## CITY OF PORTLAND

May 31, 2001

Re: 47 Custom House Wharf performance guarantee.  
CBL 30-A-1

SITE PHOTOMETRIC LIGHTING PLAN
 NOT TO SCALE

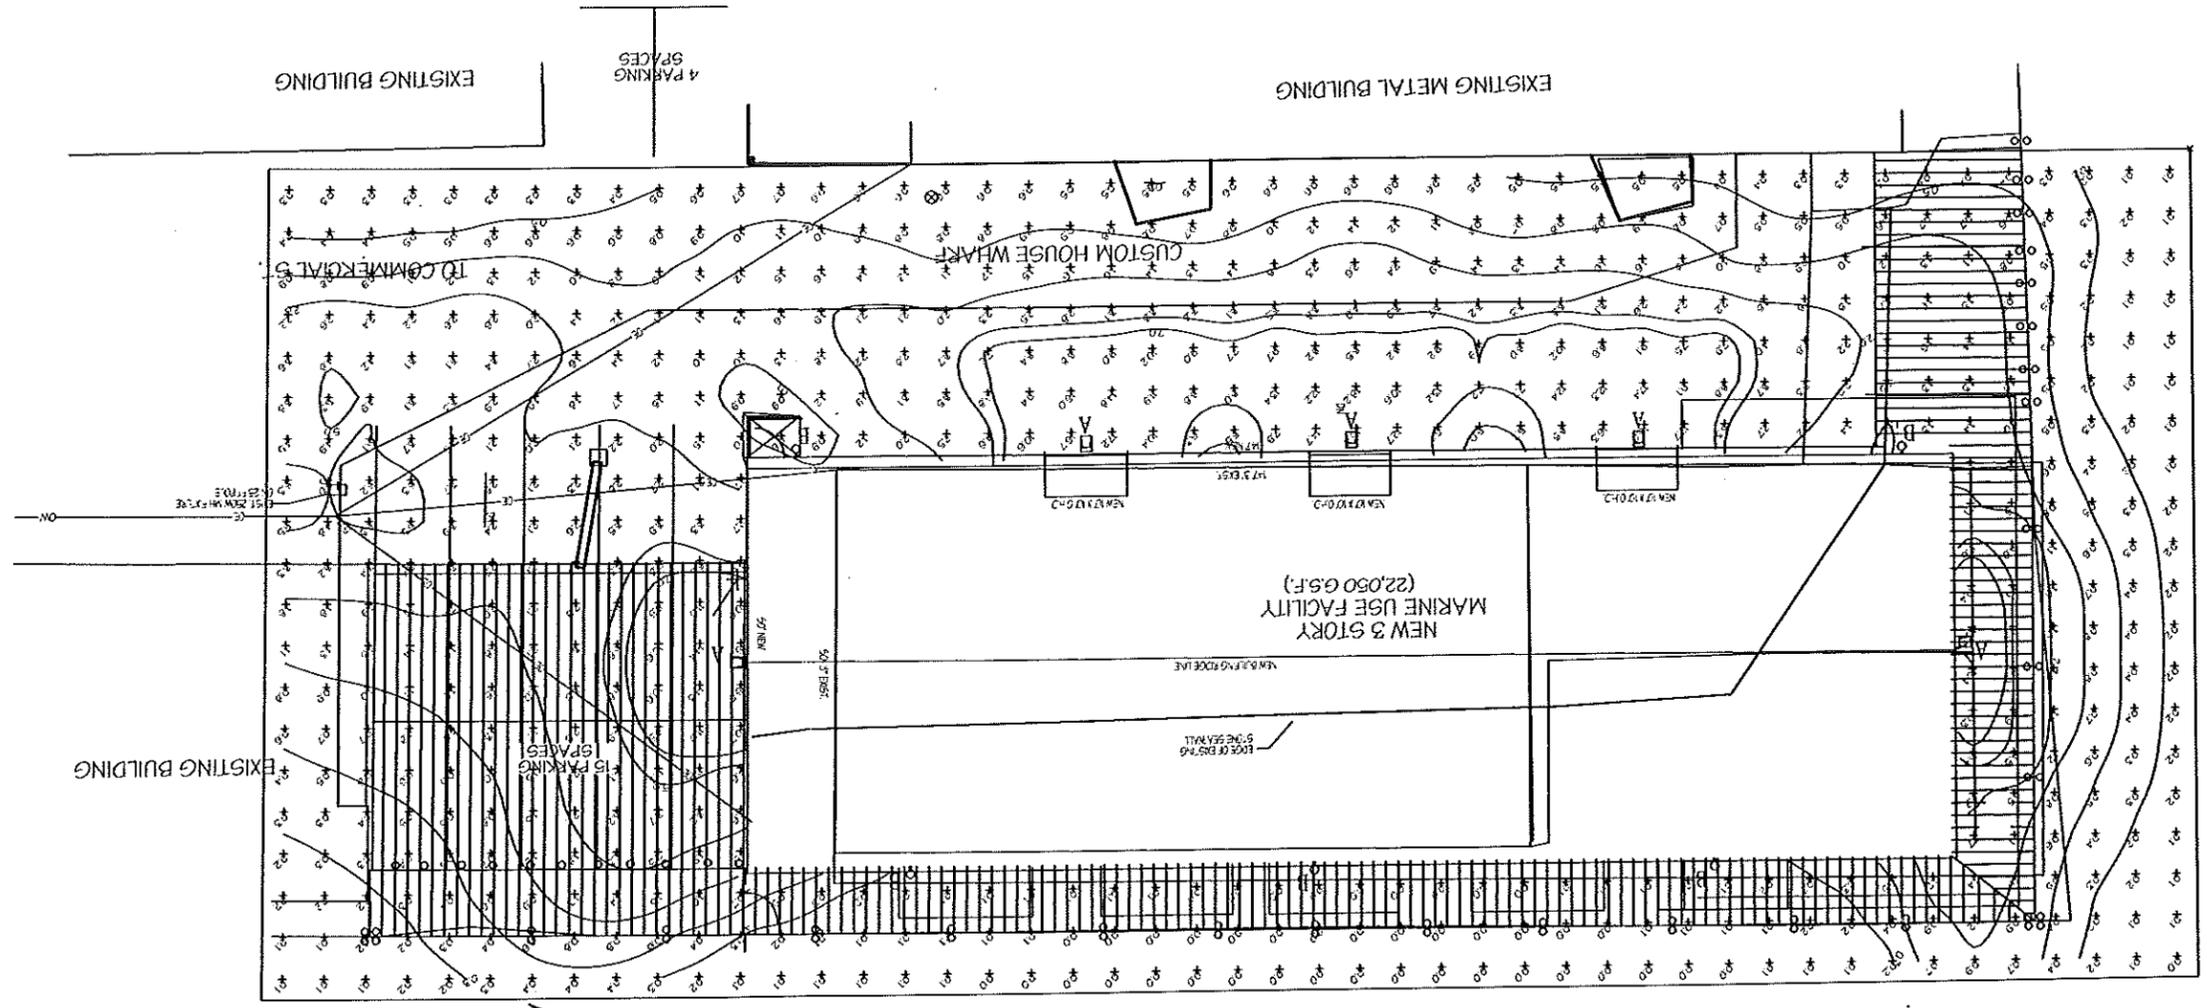
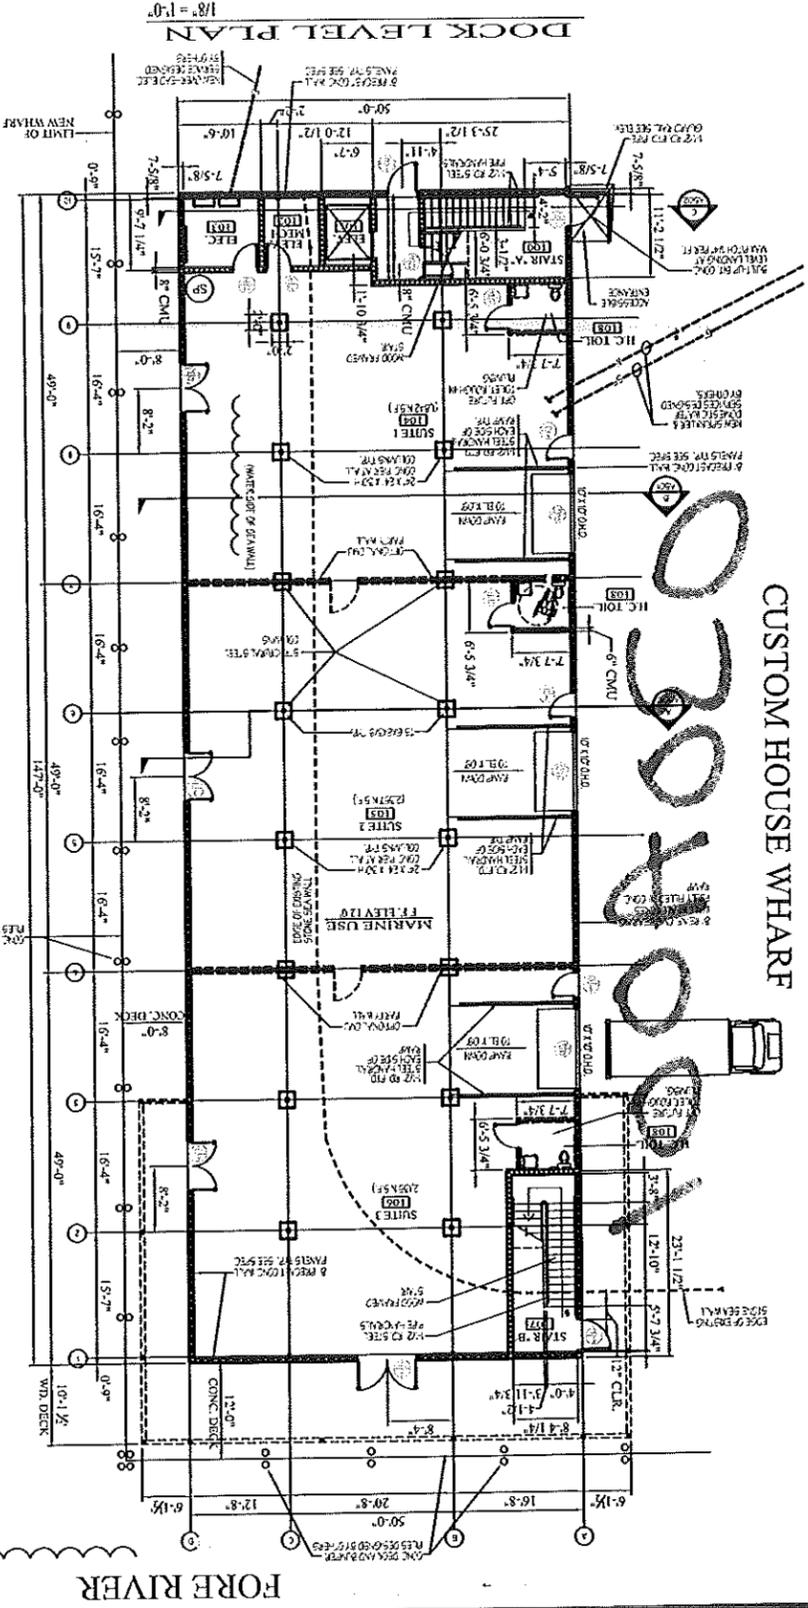
On a final note, it came to our attention that the last lighting submission, dated July 14, 2000, included three non-cut off fixtures at the pier end – fixture “c.” Please submit an alternative fixture choice for the southerly end of the pier that provides full cut off shading. If you have any questions, please contact me at any time.
